Date: 13 April 2026
Our ref: 543504
Your ref: EN020028

Application by Morgan Offshore Wind Limited and Morecambe Offshore Wind Limited (“the Applicant”) for an Order granting Development Consent for the proposed Morgan and Morecambe Offshore Wind Farms Transmission Assets (“Project”)

The following constitutes Natural England’s formal statutory response to the Secretary of State’s Request for Information (RFI) dated 12 March 2026. To inform this response Natural England has reviewed the following documents submitted into Examination by the Applicant at Deadlines 6 and 7:

Figure 1: Intertidal and Landfall Works Areas

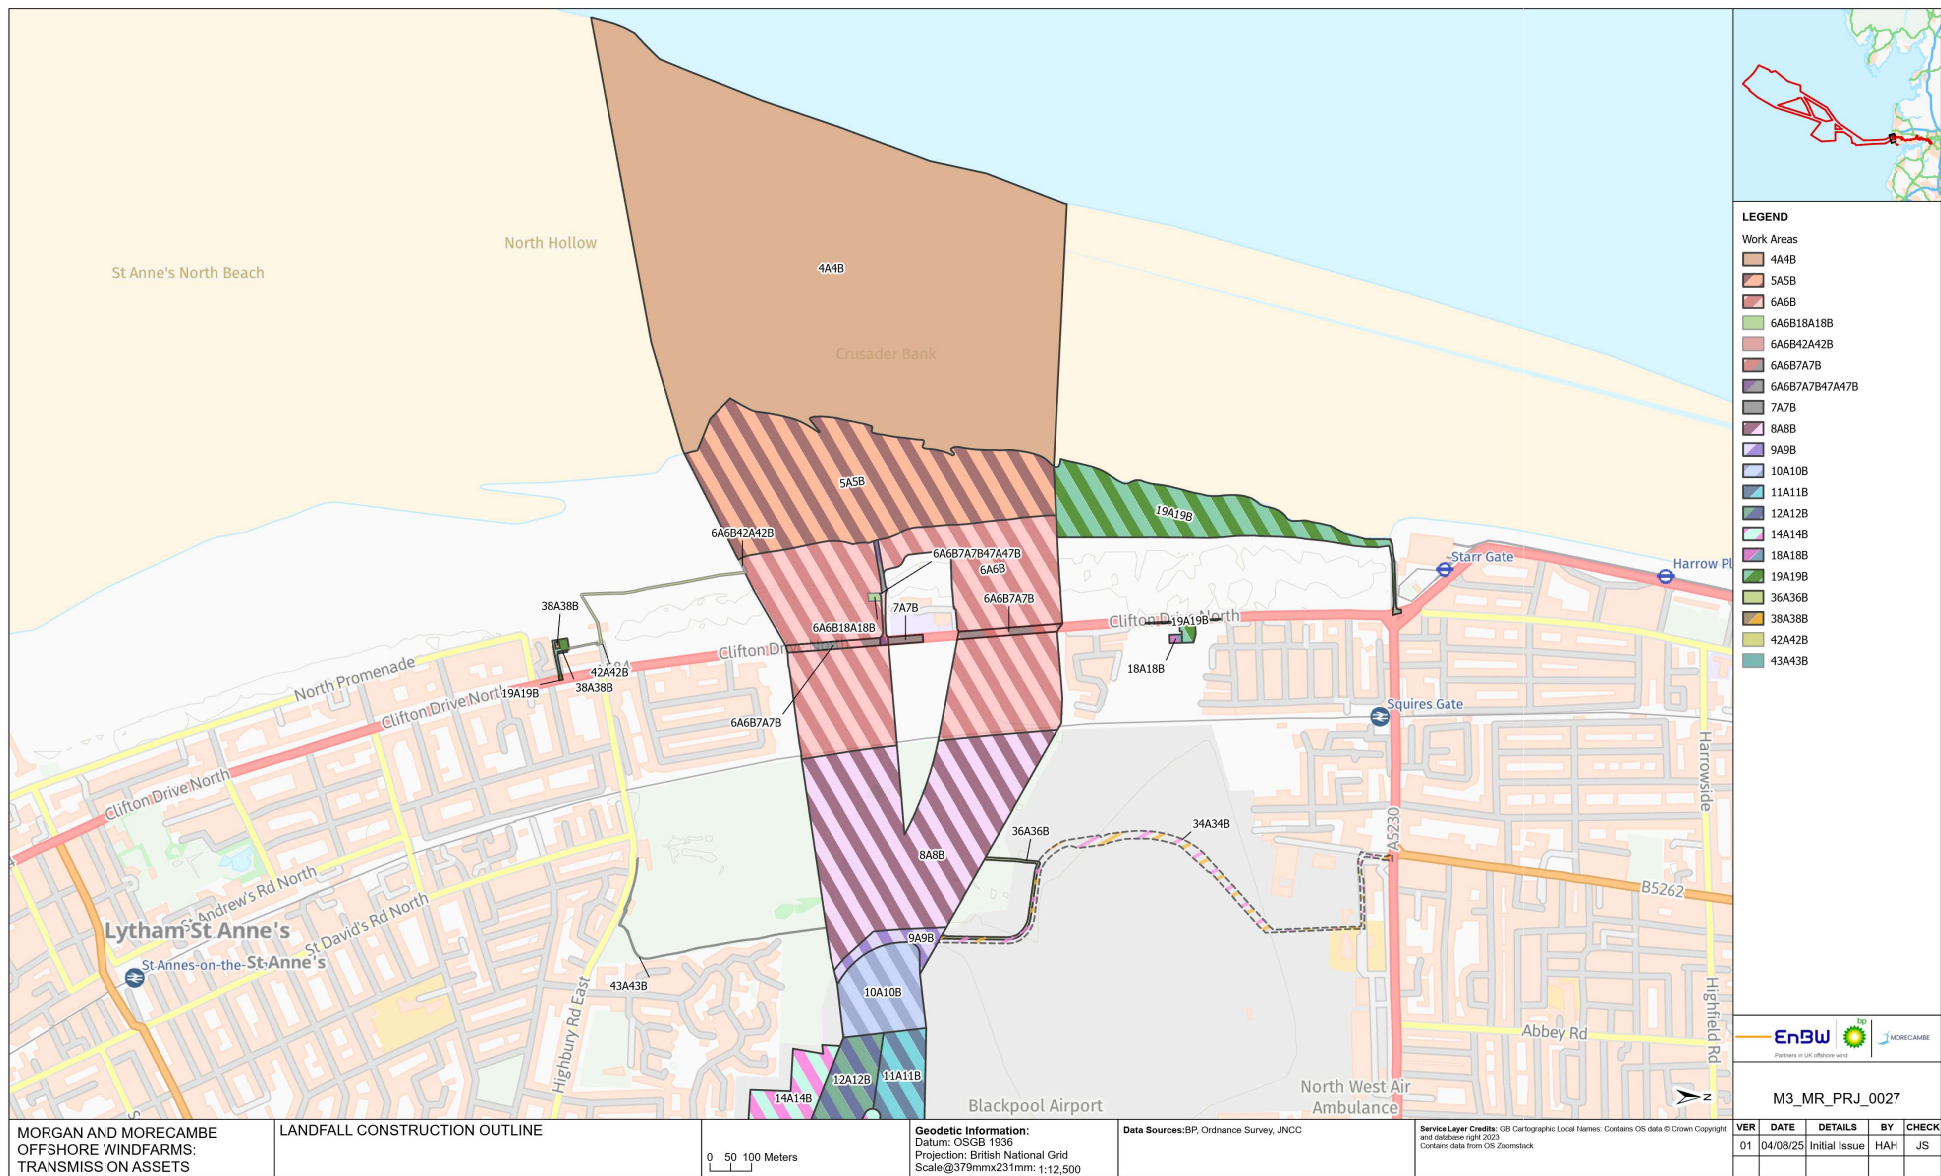
We acknowledge and welcome that the intention is for the Applicant to bury the cables in the intertidal and nearshore. We also note that the Applicant has updated the wording of CoT133 at Deadline 7 [REP7-009] to state “*no cable/scour protection shall be deployed in the intertidal area between Mean Low Water Springs (MLWS) and Mean High Water Springs (MHWS) during the construction and operation and maintenance phases*”. This addresses risks and issues raised in relation to disruption of sediment transport over the lifetime of the project.

However, with regards to temporary infrastructure in the intertidal, insufficient evidence on the duration of the impacts and potential changes to marine and coastal processes has been presented to support the argument that the benefits of using the cofferdams outweigh the loss of sediment. As with other marine Cable NSIPs we advise mitigation measures such as the first project installing the ducts for both projects should be considered to facilitate recovery. In the absence of the information and proposed mitigation we continue to advise that monitoring of geomorphological receptors in the intertidal should be considered (please see below in ‘*Monitoring*’).

Figure 4: Indicative Beach Working Areas for Cable Installation Works

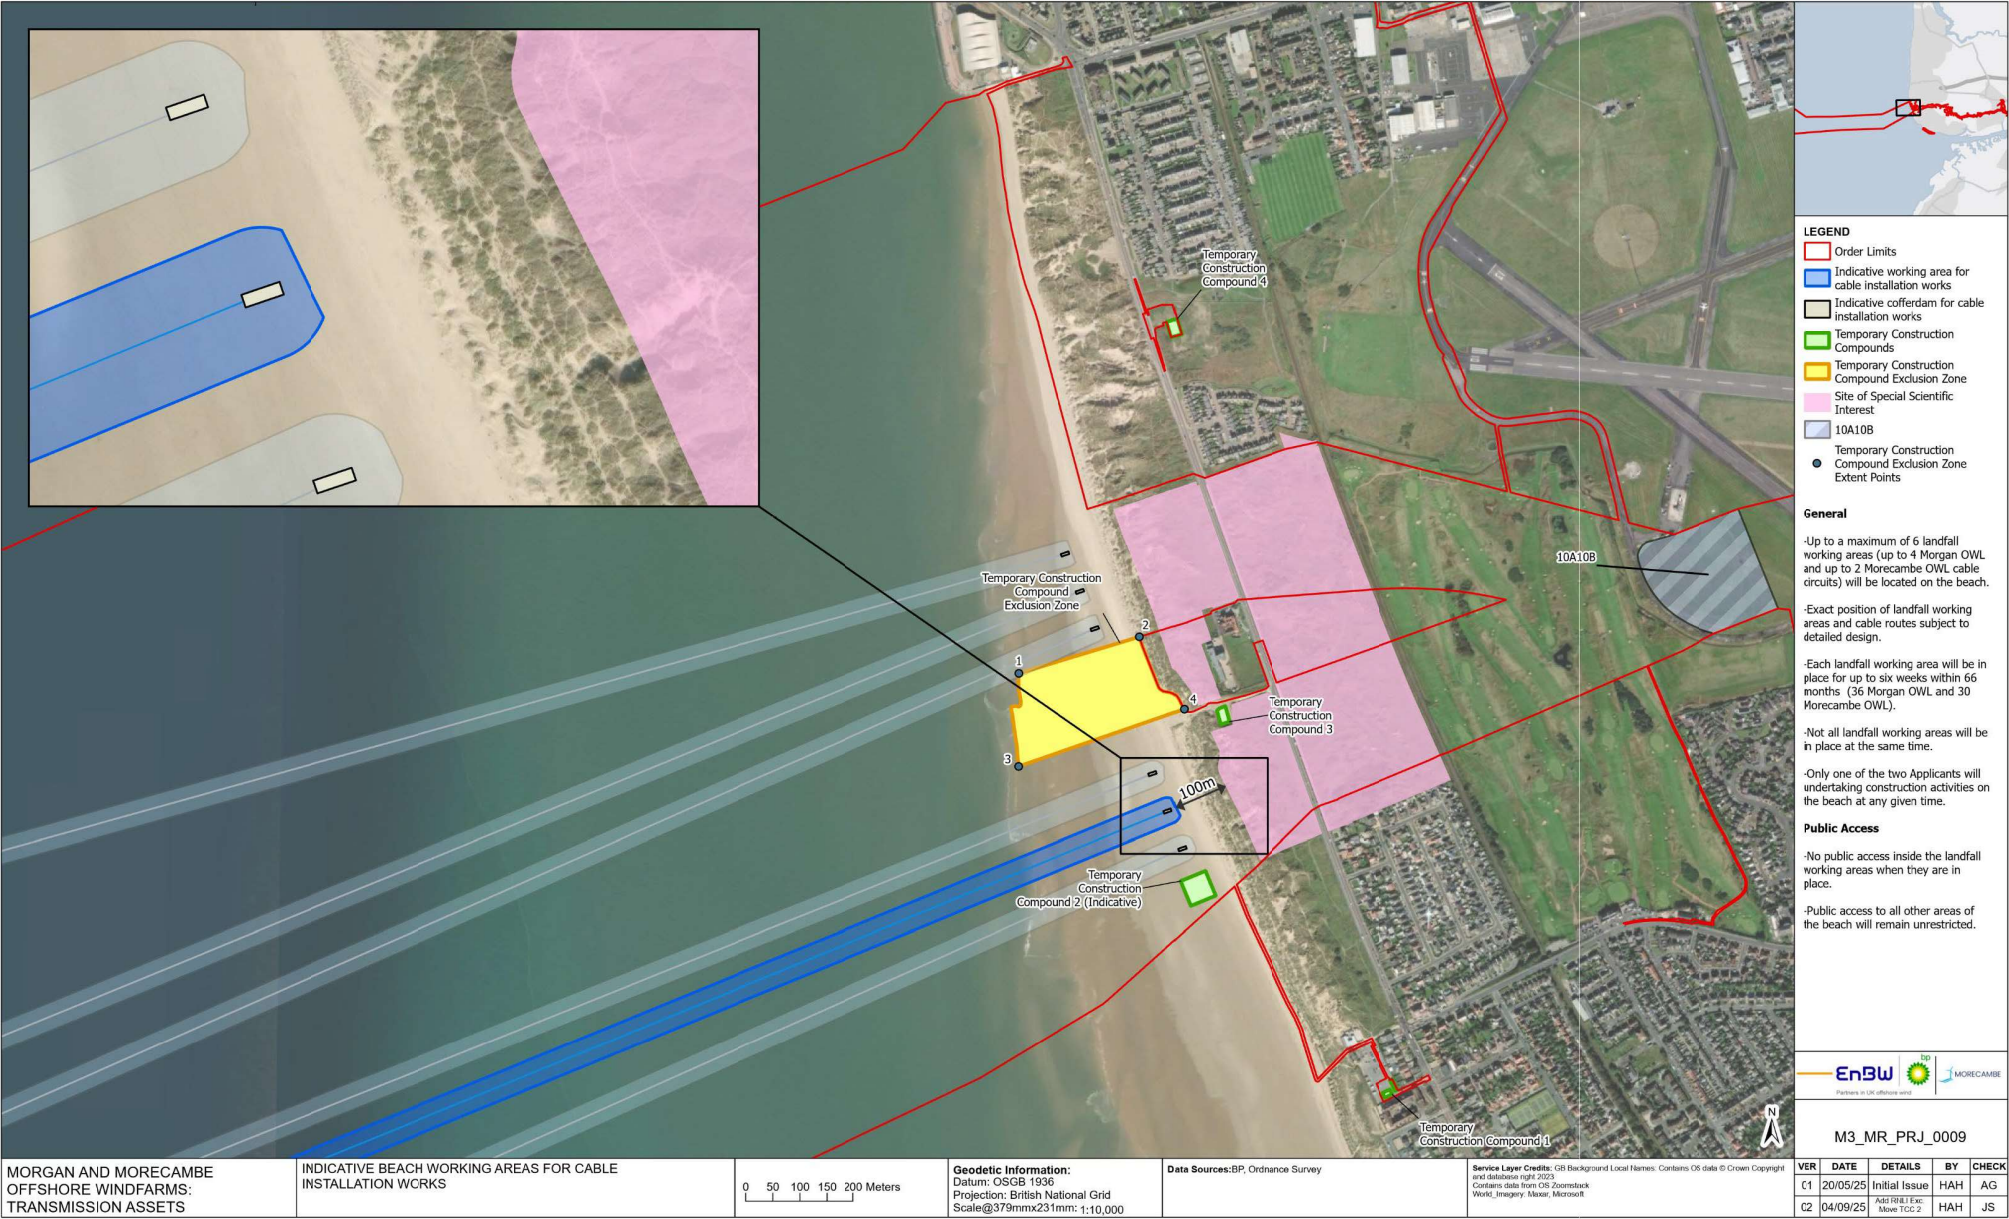
- CoT39 – Concerns remain as the commitment does not flag that the works are located within the Ribble Estuary SSSI, where ‘Assemblages of breeding birds – Sand dunes and saltmarshes’ are a supporting interest feature of the site. This comment is captured in ref 2 [REP-182].

- CoT44 - We reiterate that clarification is needed on the 100m distance from the works to Lytham St Annes Dunes SSSI. As previously advised the sand dunes are accreting, therefore whilst the distance from the SSSI site boundary from the works may be 100m, the distance from the frontal dunes is likely less (approximately 50m) (ref 2 and ref 3 [REP5-182]), when considering the accretion to the edge of the frontal dune. Therefore, depending on the actual distance to the dunes (when works commence) there may be potential for impacts from construction works at landfall. This comment is captured in ref 3 [REP-182] and reflected in RI_G49 on [REP6-193].

- Clarity of the depth of cable burial under the dunes, which should take into consideration data presented in the NVC survey, and hydrological monitoring (presented in the Hydrological Risk Assessment) as detailed in CoT128. Further information is available in RI_G1 [REP6-193]. In summary our outstanding concerns at Deadline 6 relating to cable burial depth and impacts on Ground Water Dependent Terrestrial Ecosystems (GWDTE) i.e. dune slack vegetation have not been progressed. The Outline Hydrogeological Risk Assessment of Lytham St Annes Dunes SSSI ([REP6-140], paragraph 6.1.1.2) notes that *“further evidence for a shallow water table within one metre of the surface was observed to the east of the dunes”,* going on to say, *“it is not known whether this is laterally extensive further to the west”*. The NVC survey data should be used to inform understanding of the ground water hydrology providing an insight of locations where a shallow water table exists due to the presence of dune slack vegetation. In addition, paragraph 6.1.1.4 flags that if the cable is installed within the blown sand there is a high risk that the water table will be dewatered as a result of cabling. However, if cabling occurs within the glacial clays, the risk is very much reduced. Paragraph 6.1.1.2 also notes *“the site has a relatively simple hydrogeological conceptual model, supported by boreholes advanced to the west and east of the dune system. These proved the thickness of the blown sands deposits making up the dunes to be 14 metres in thickness”*. Therefore, Natural England need confirmation that the cable will be buried in the glacial clays (below 14m) and that cabling at this depth is technically feasible, especially at this location where the cable needs to emerge on both sides of the dunes within the Transition Joint Bays (TJBs). Additional boreholes may be required within the dune system along the actual alignment of the proposed cables, to determine the depth of glacial clays. In addition, further

- Detail on the cable alignment under Lytham St. Annes Dunes SSSI and St. Annes Old Links Golf Course BHS (R1_G9, [REP6-193]). As noted in R1_G3 [REP6-193] we require further details of the location of TJBs in Blackpool Airport and the foreshore, the cable alignment under the sand dunes and cable depth to determine the potential for impacts on sand dune SSSI features associated with Lytham St. Annes Dunes. This issue was raised in our Relevant Representations and captured in R1_G9 [REP6-193], “depending on the required distance between the cables this could result in the cables underlying a significant proportion of the SSSI dunes and relict dunes”.

- Distance between the 6 cables considering the potential effects of heat transfer noted in R1_G9 [REP6-193] and combined effects of drought noted in R1_G10 [REP6-193] have not been considered.
